Submission on DA and EIS – Brookvale Community Health Centre (SSD 6980)

Council Submission

Brookvale Community Health Centre State Significant Development Application (SSD 6980)

3 December 2015

1 ELEVATION - MAIN BUILDING WEST A
1 : 200

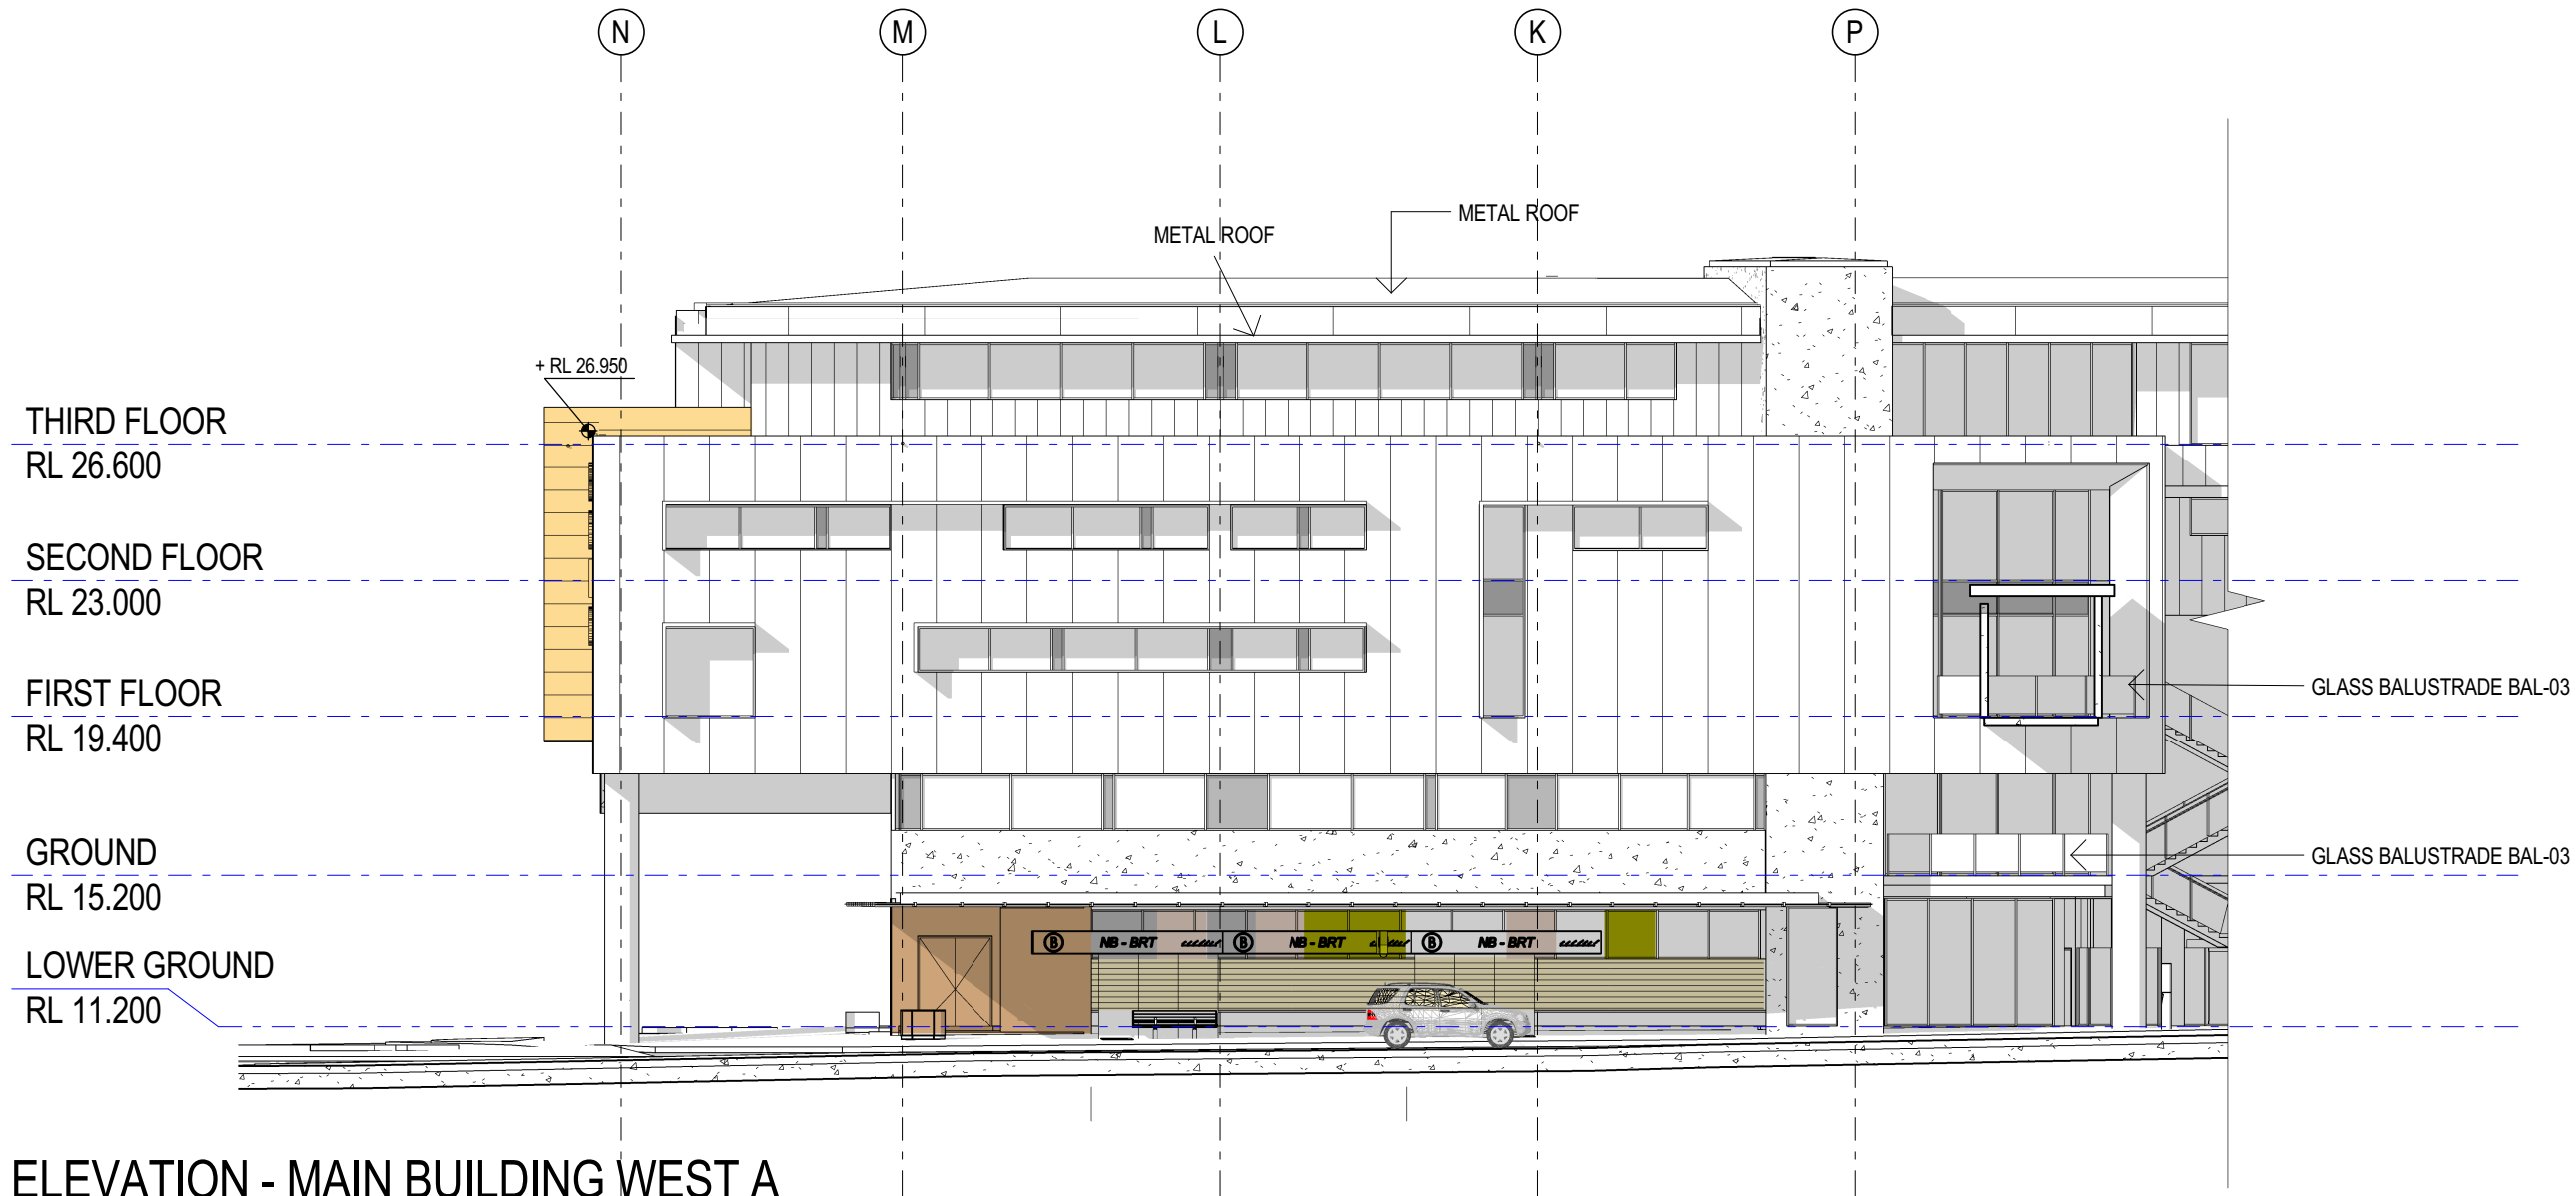
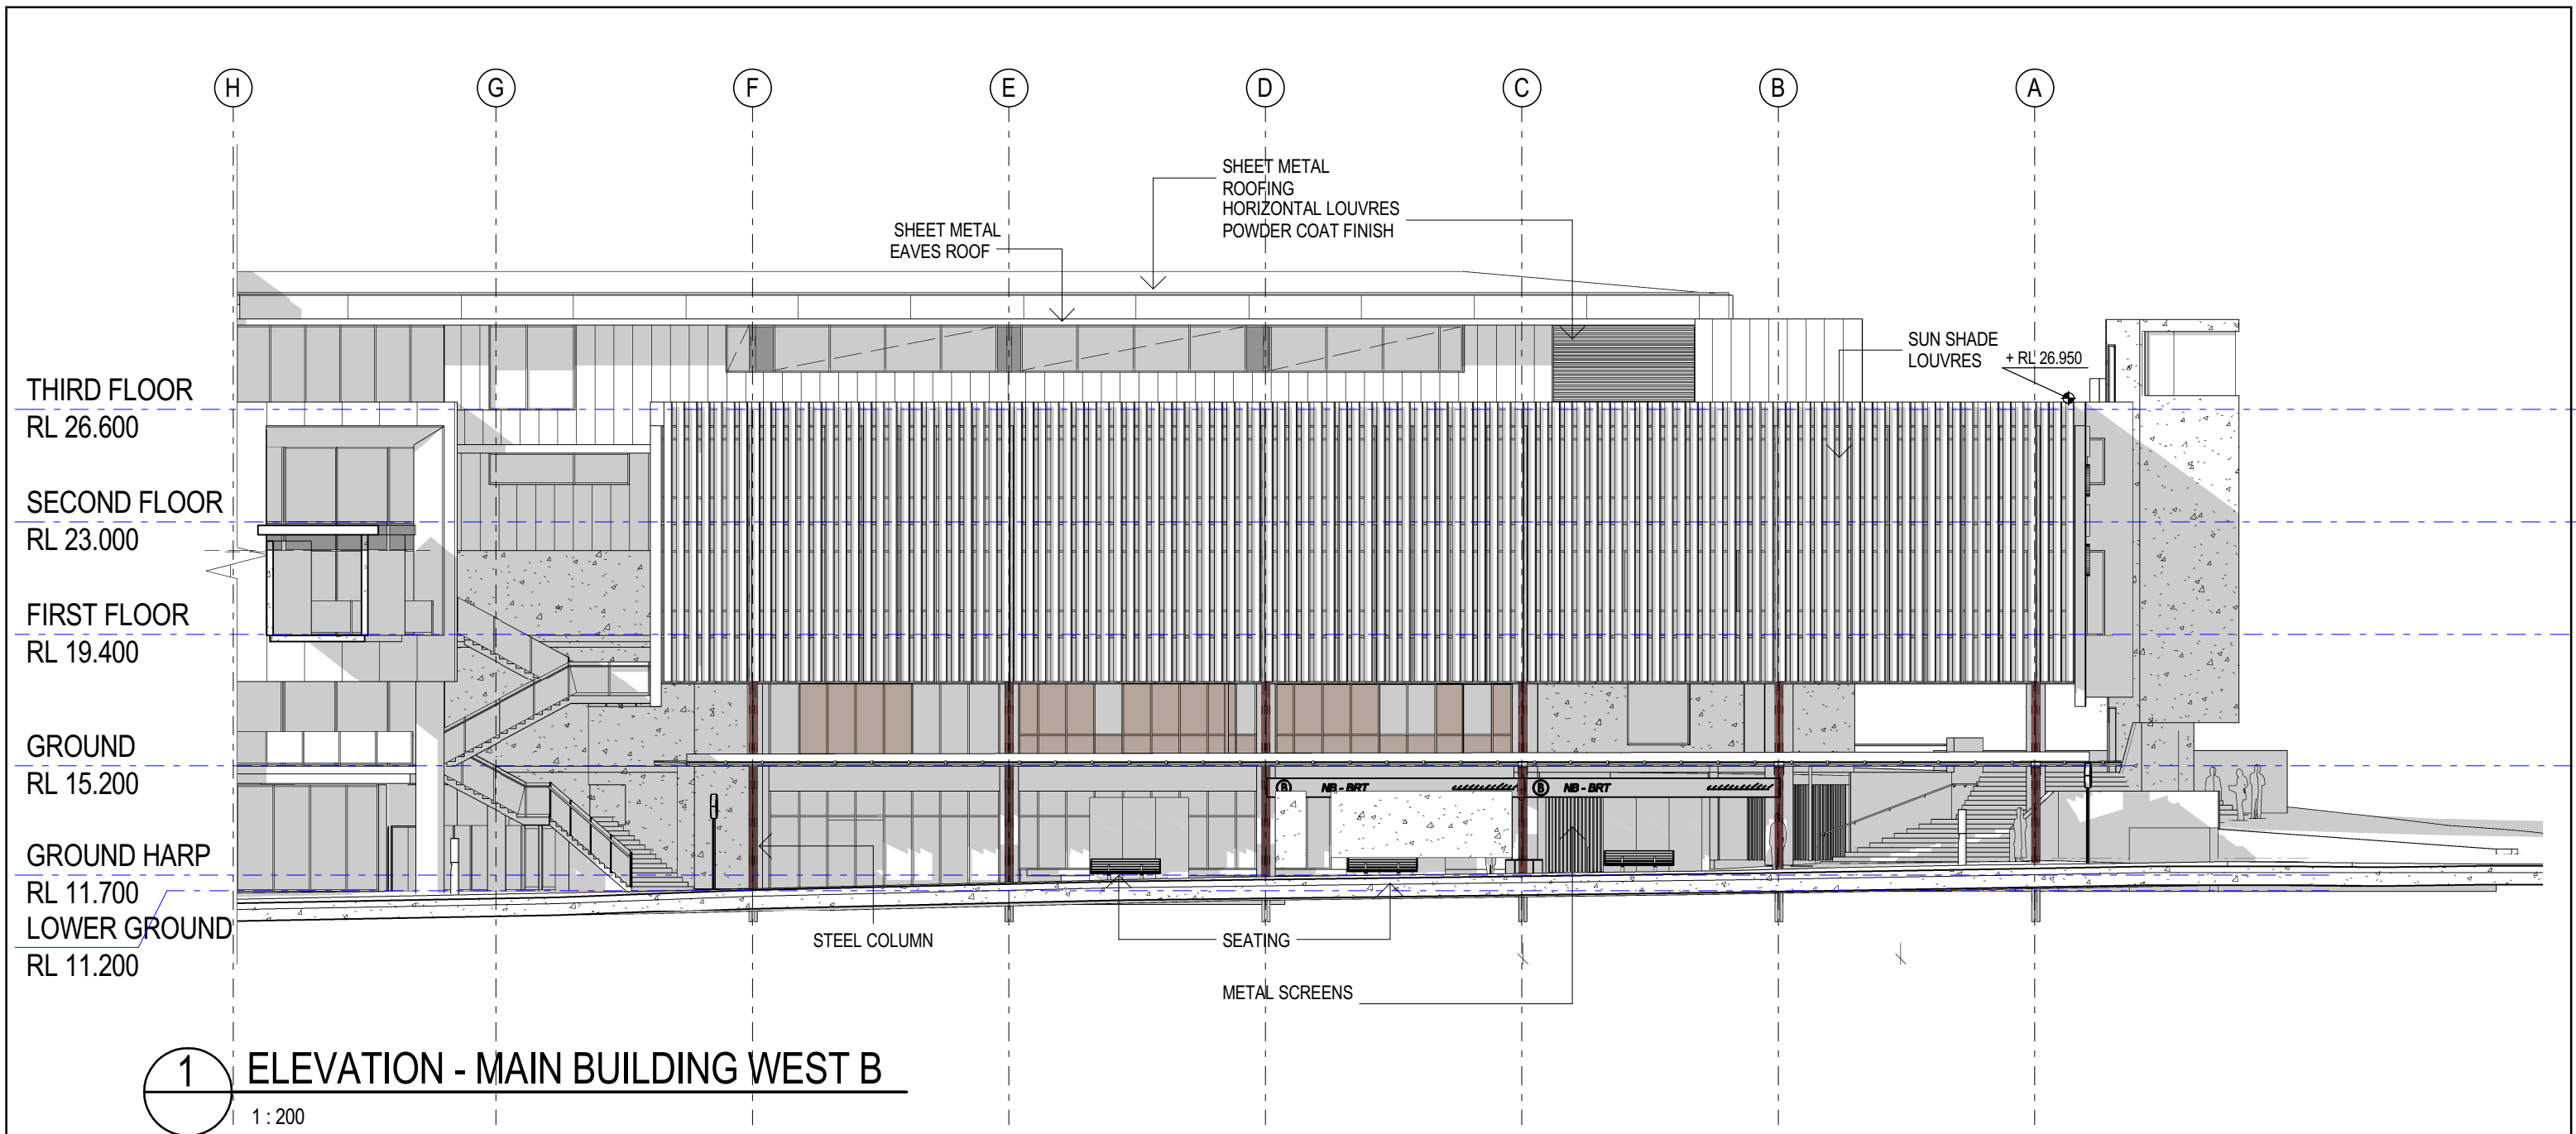
- A greater front setback to Pittwater Road, especially the portion of the building that sits on the deeper area of the site to the north (adjoining the Ebs-ray Building and the Bus Depot).
- The front facade to Pittwater Road could be curved, such that a greater setback would be provided to the southern corner with William Street and the northern corner with the Ebs-ray Building. It is strongly recommended that the façade be articulated in ways to achieve a greater setback on the respective front corners to lessen the visually dominant scale of the building and its overbearing impact on the public domain.

- While both ends of the building facing Pittwater Road are important, the priority is the south west corner, given that it acts as a “Gateway” to Brookvale and will be very visible, sitting on the corner of this busy intersection. Council would like to see the south-west corner of the building softened with more rounded or curved elements introduced and through the use of innovative architecture and materials/colour/texture.
- The block stairwell on the southern elevation facing William Street should be incorporated into the building rather than being attached to the front of the building; otherwise, a more innovative treatment of this structure should be investigated to improve the aesthetics of the building. Council is seeking a clean and simplified building form on the southern elevation.

- Due to the solid treatment of the block stairwell material and the 5 storey ‘chimney’ like effect, it does not present a fitting ‘gateway’ statement to Brookvale.
- A better approach will be to integrate the stairwell into the main building form presenting a more organised and less busy looking corner. The corner building signage can also work better with this ‘cleaner’ minimalist building aesthetics.

The Pittwater Road facade integrates various functions of a bus and people interchange with the incorporation of the bus stops and the overhead pedestrian link bridge. It is currently a very ‘busy’ looking complex and the building aesthetics can work towards a more ‘unifying’ function with a less complicated facade treatment.

1 ELEVATION - CARPARK SOUTH
1 : 200

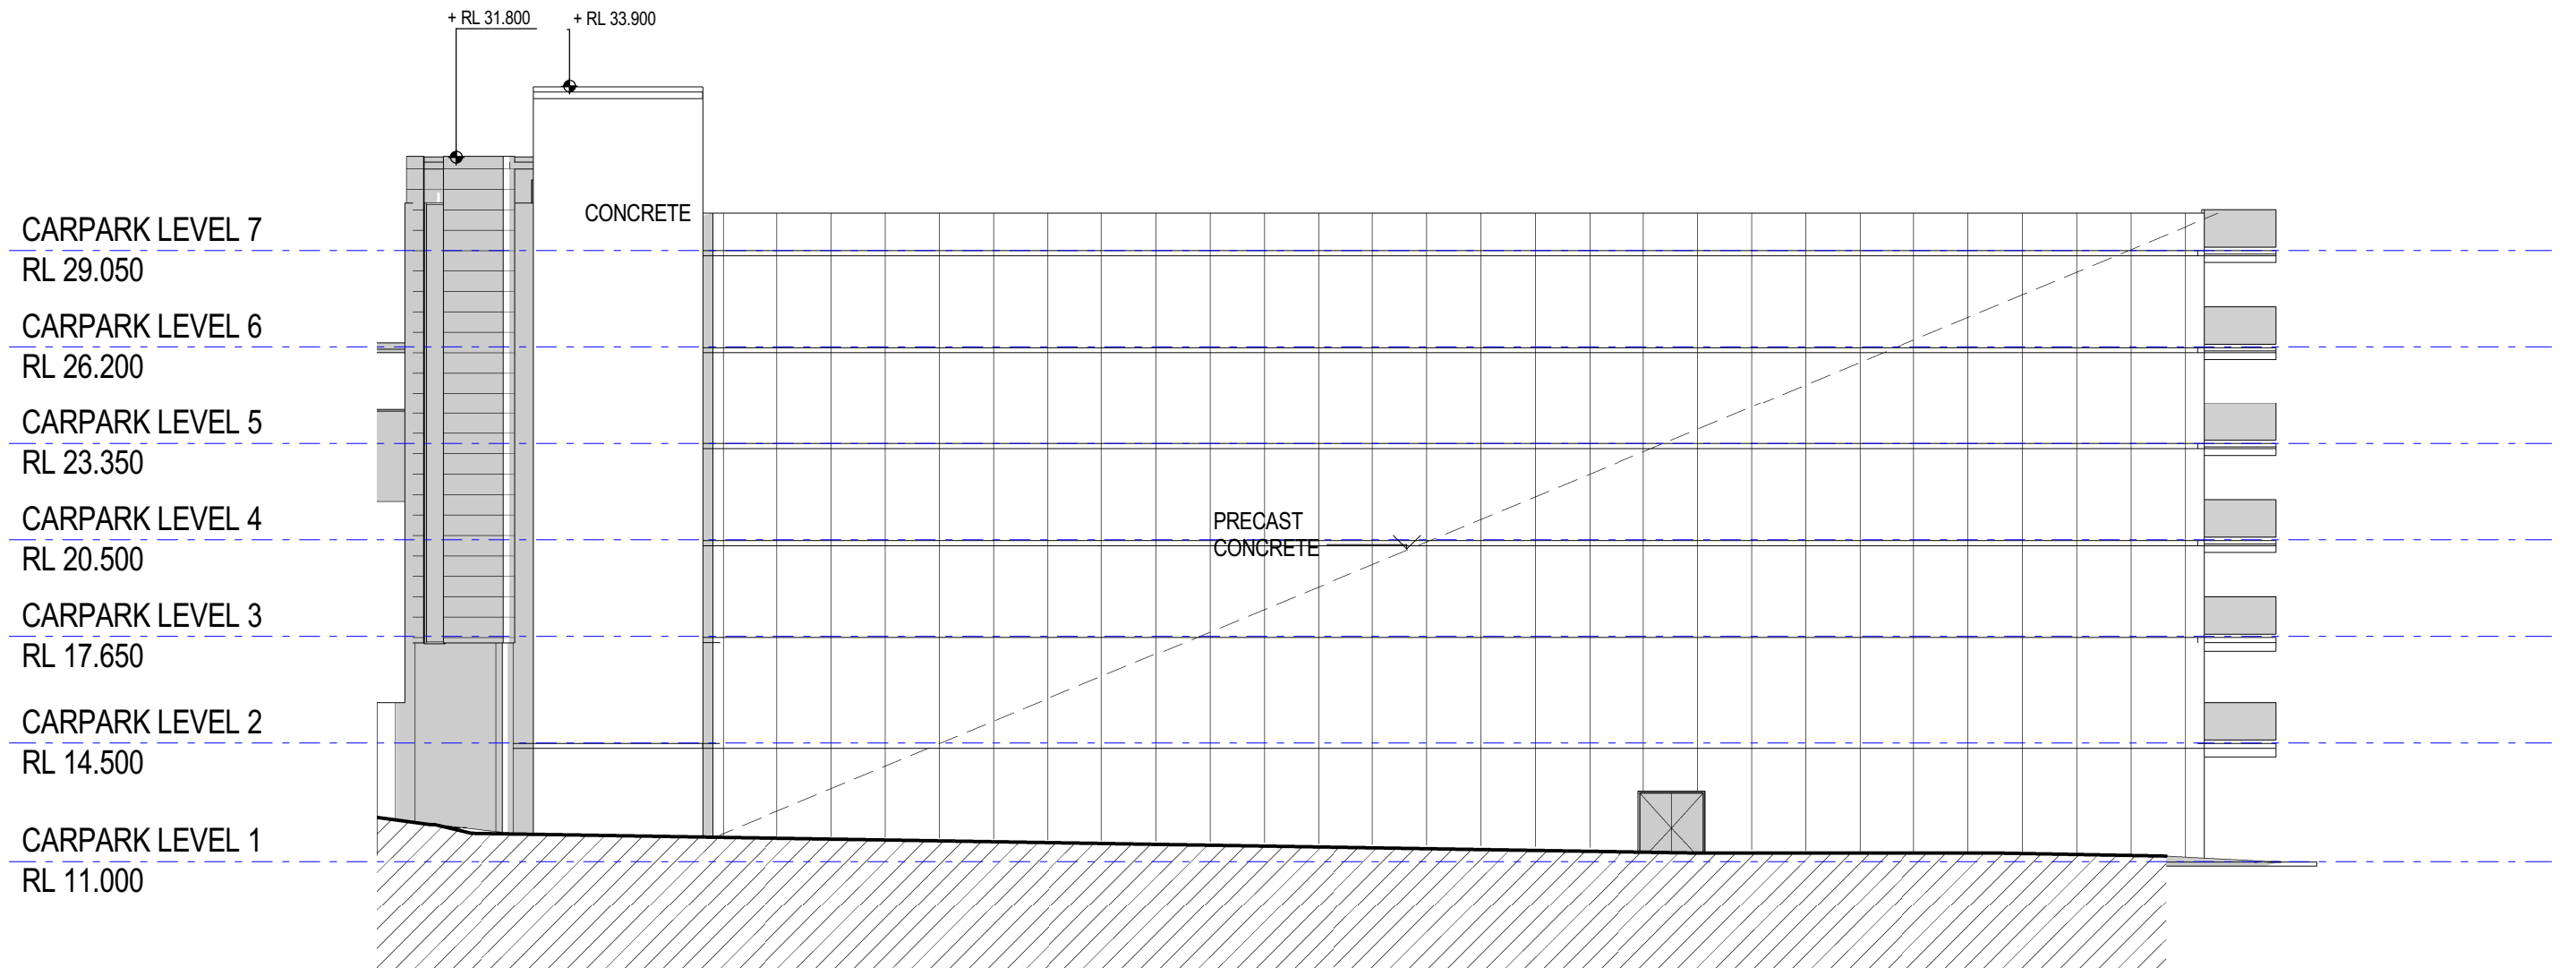
In addition to the Development Assessment comments above, Council's Urban Designer would like to add these further comments, specifically in relation to the block stairwell on the southern elevation:
